Ref 2022/0930 – Planning Application

Proposal: Conversion of building into new sandwich bar/delicatessen style food outlet with 2no football match day sales kiosks and associated internal and external works including replacement shop front, food cooking and preparation area, internal customer waiting area, staff facilities and integral storage units

Address: Rockingham Bakery, Windermere Road, Barnsley, S71 1EG

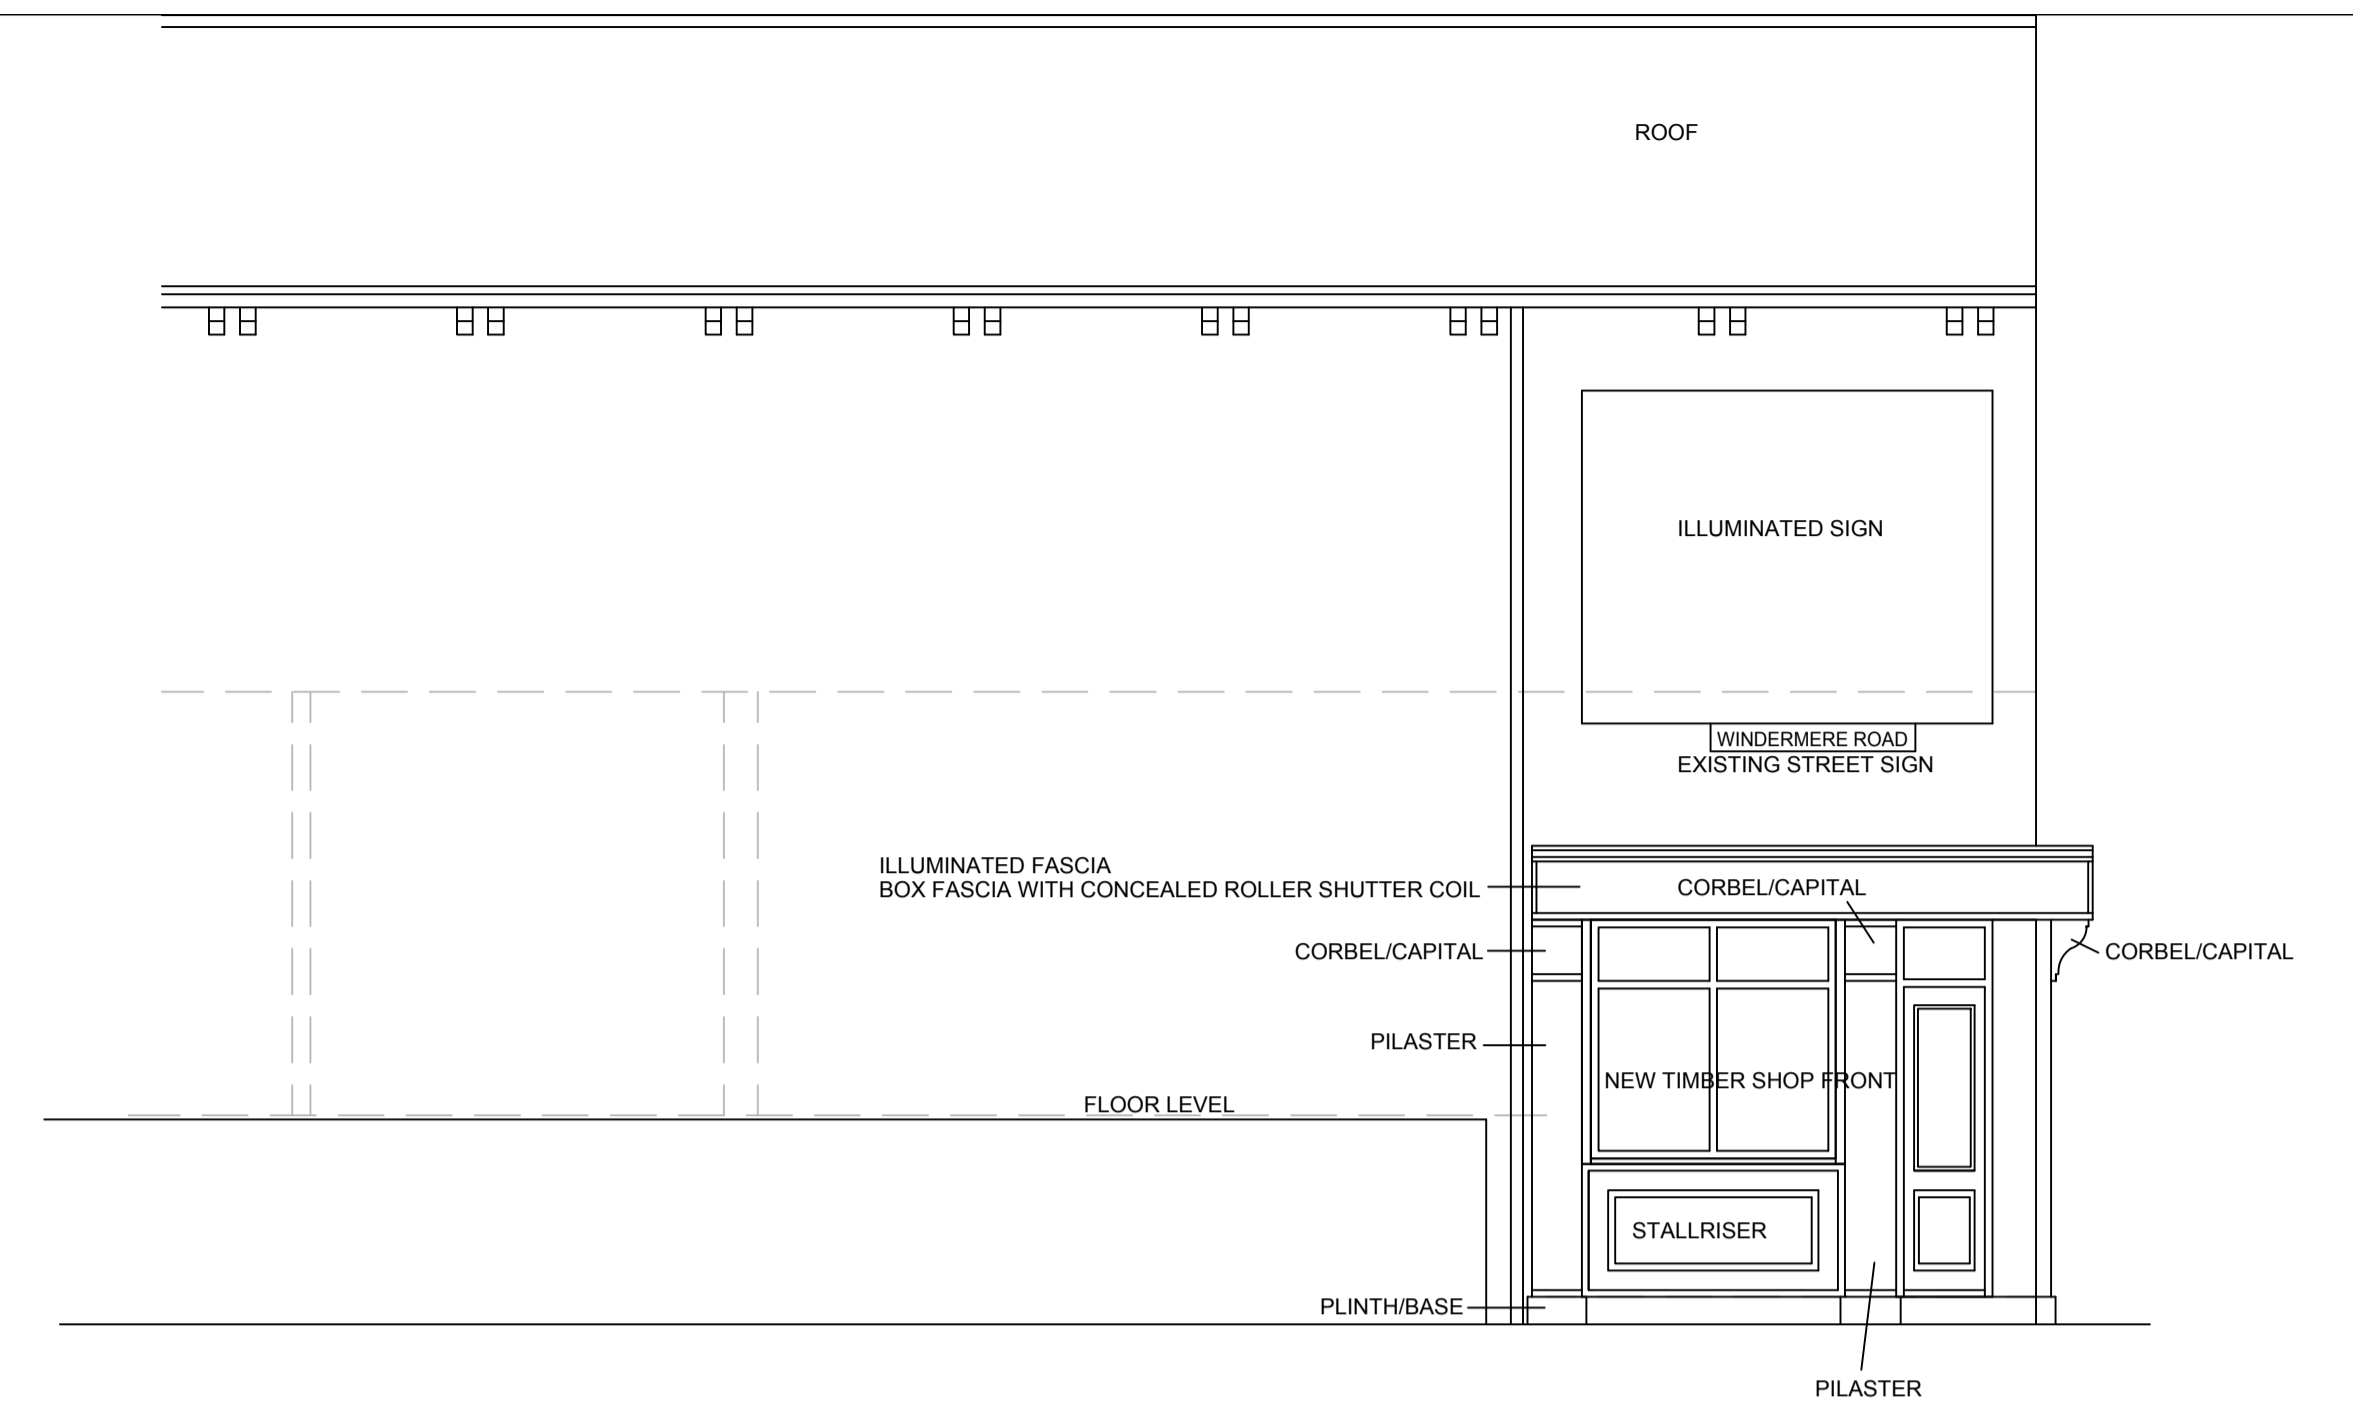
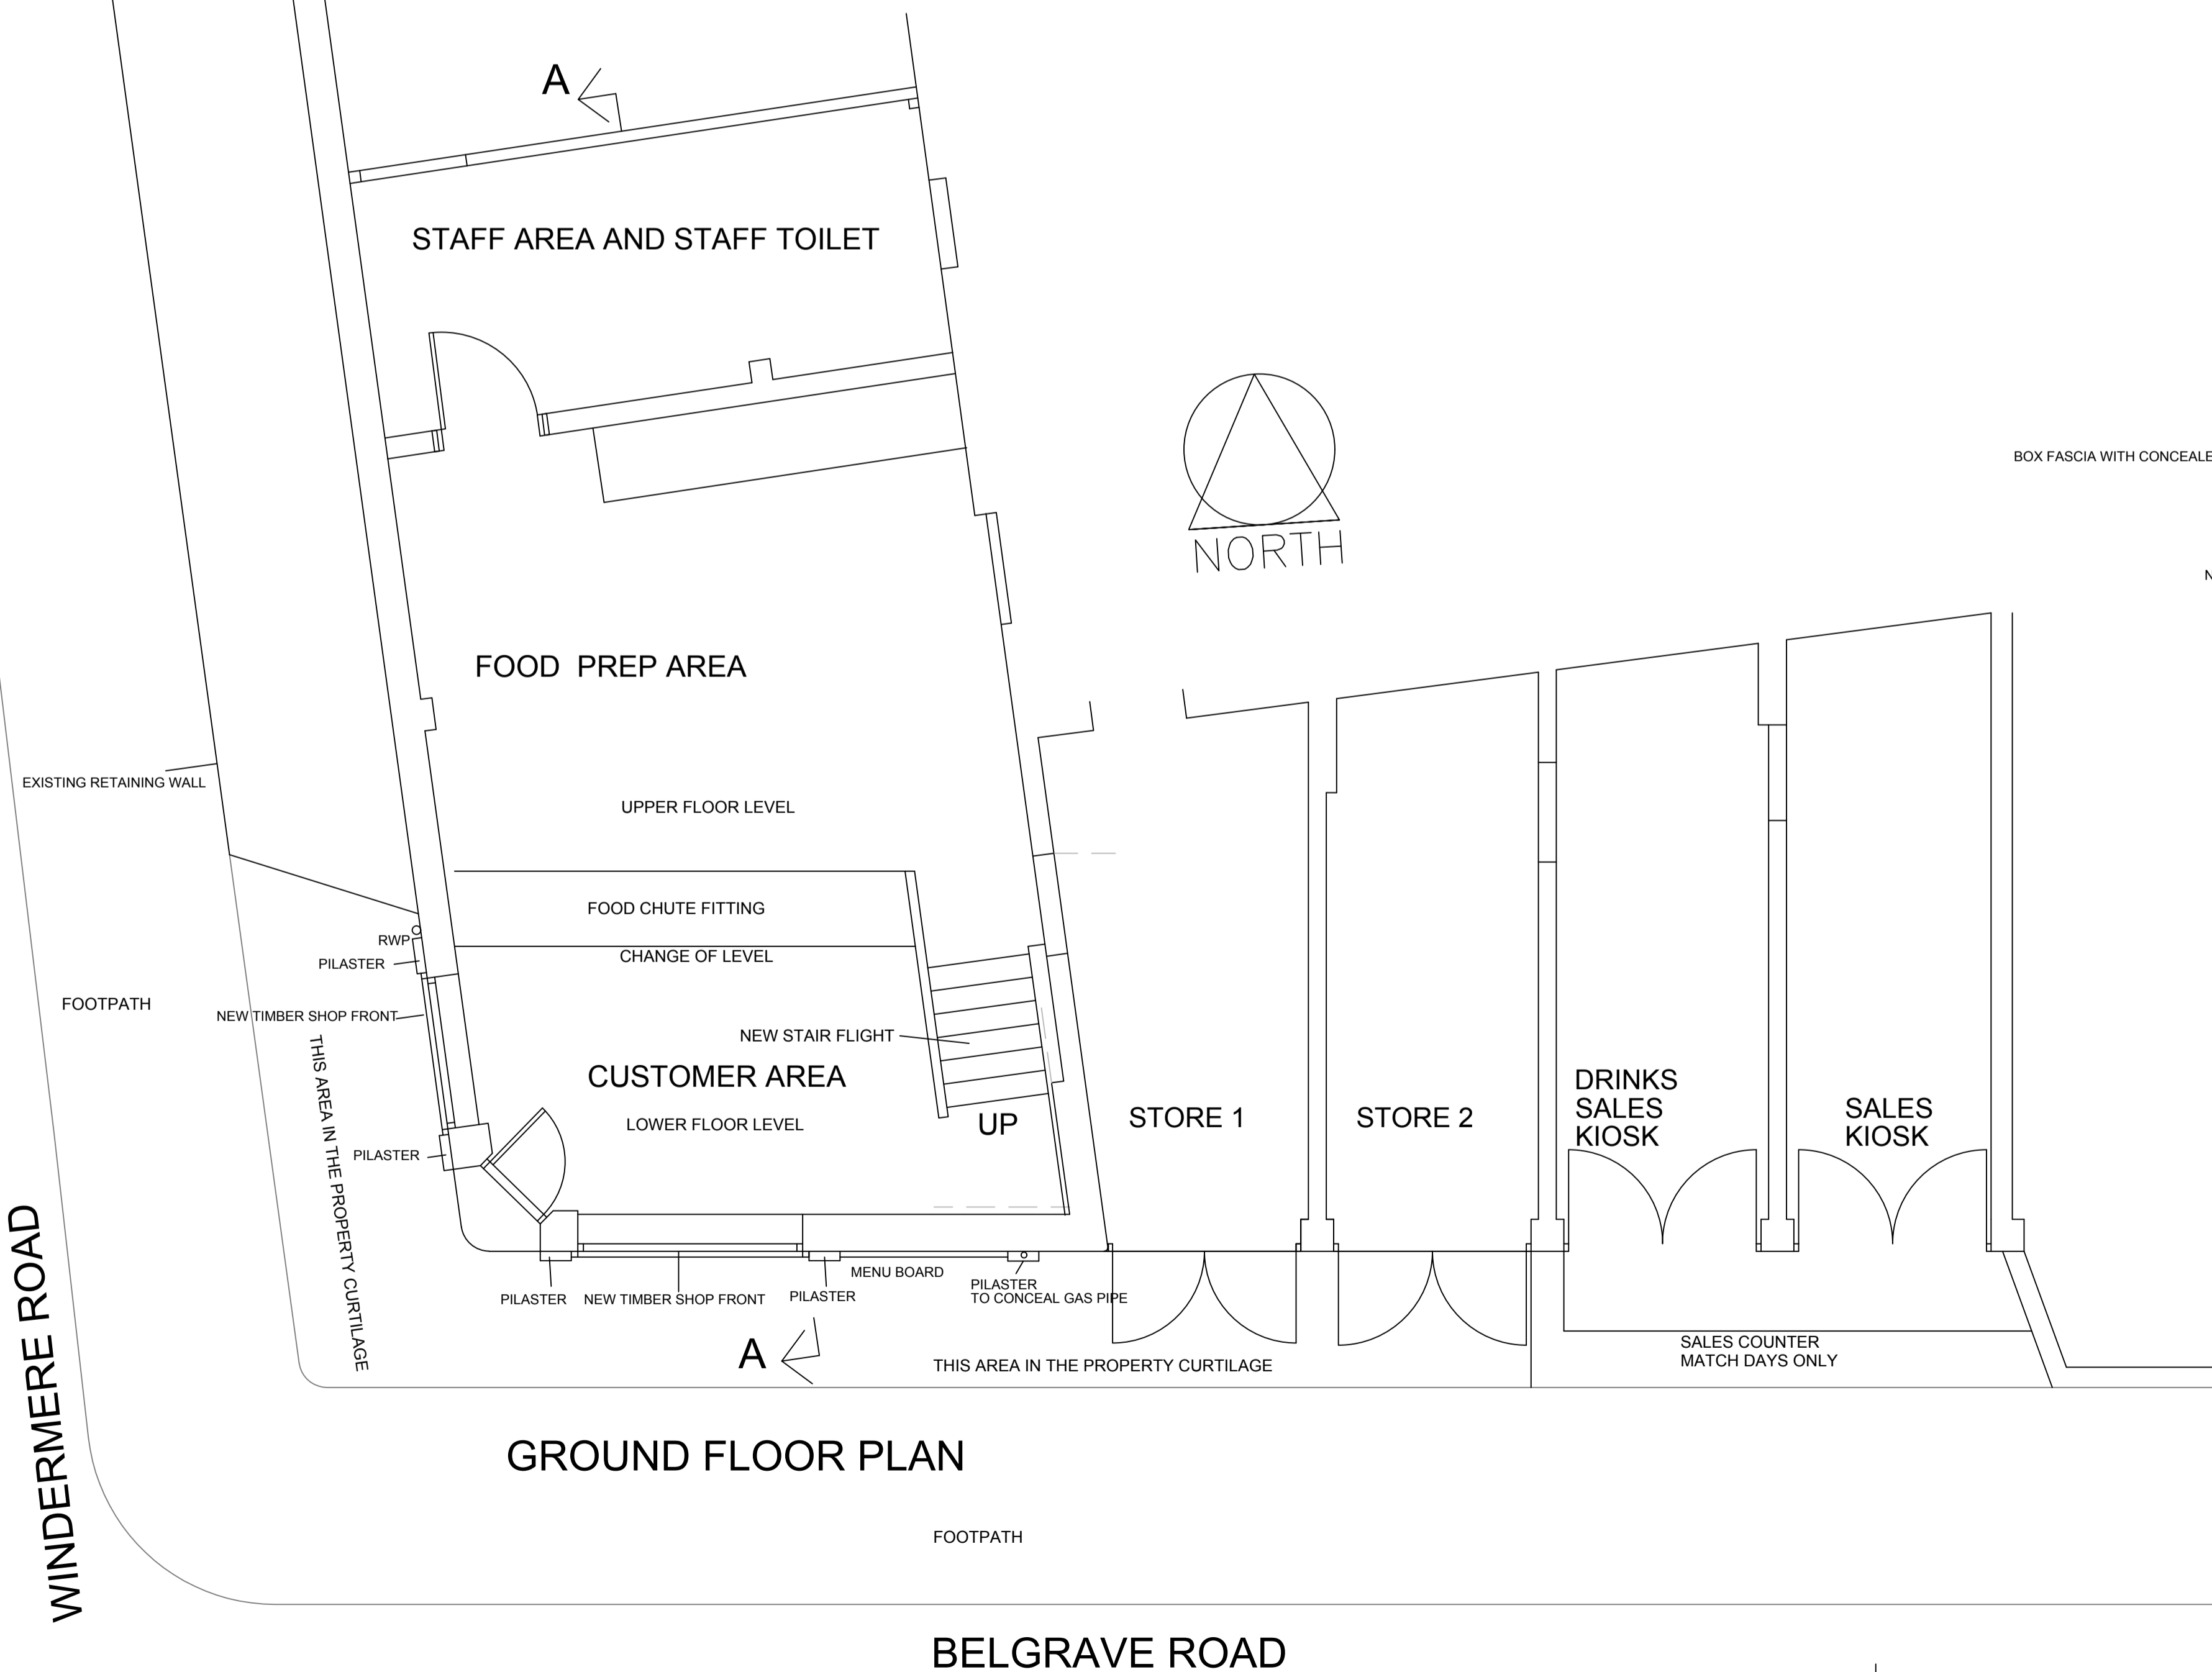
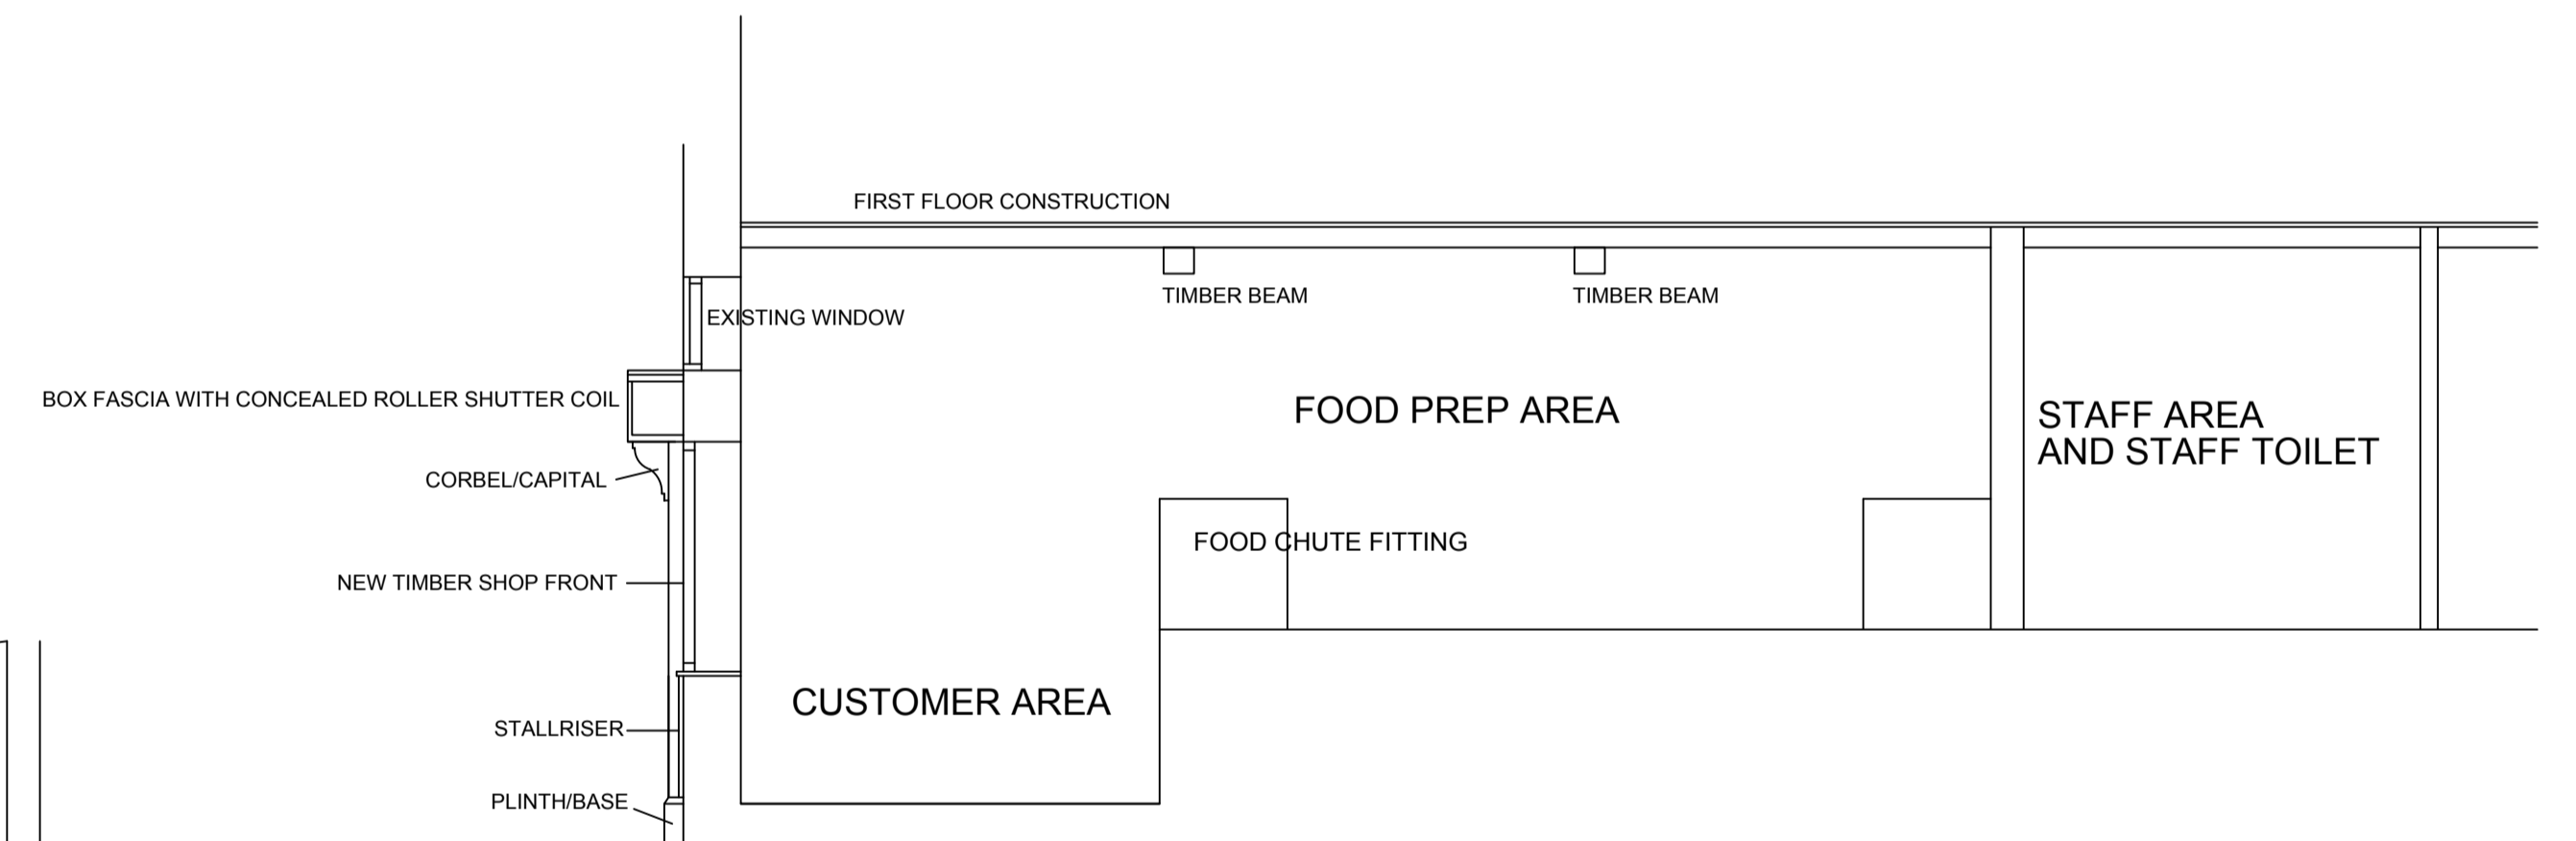
In addition the originally proposed flue has been removed in the amended plan, on advice that it was inappropriate in this setting. The applicant has confirmed that some form of flue or other fixed building services will be required to deal with cooking smells as food such as bread, sandwich and salad fillings and soup will be cooked on the premises.

The design of the proposed shopfront alterations which would re-instate a traditional painted timber shopfront is considered to be acceptable. The originally proposed flue has been removed from the scheme. Subject to a condition requiring the colour finish of the shopfront to be agreed (and the flue condition referred above) it is concluded that the proposals are considered to be in compliance with Local Plan Policy D1.
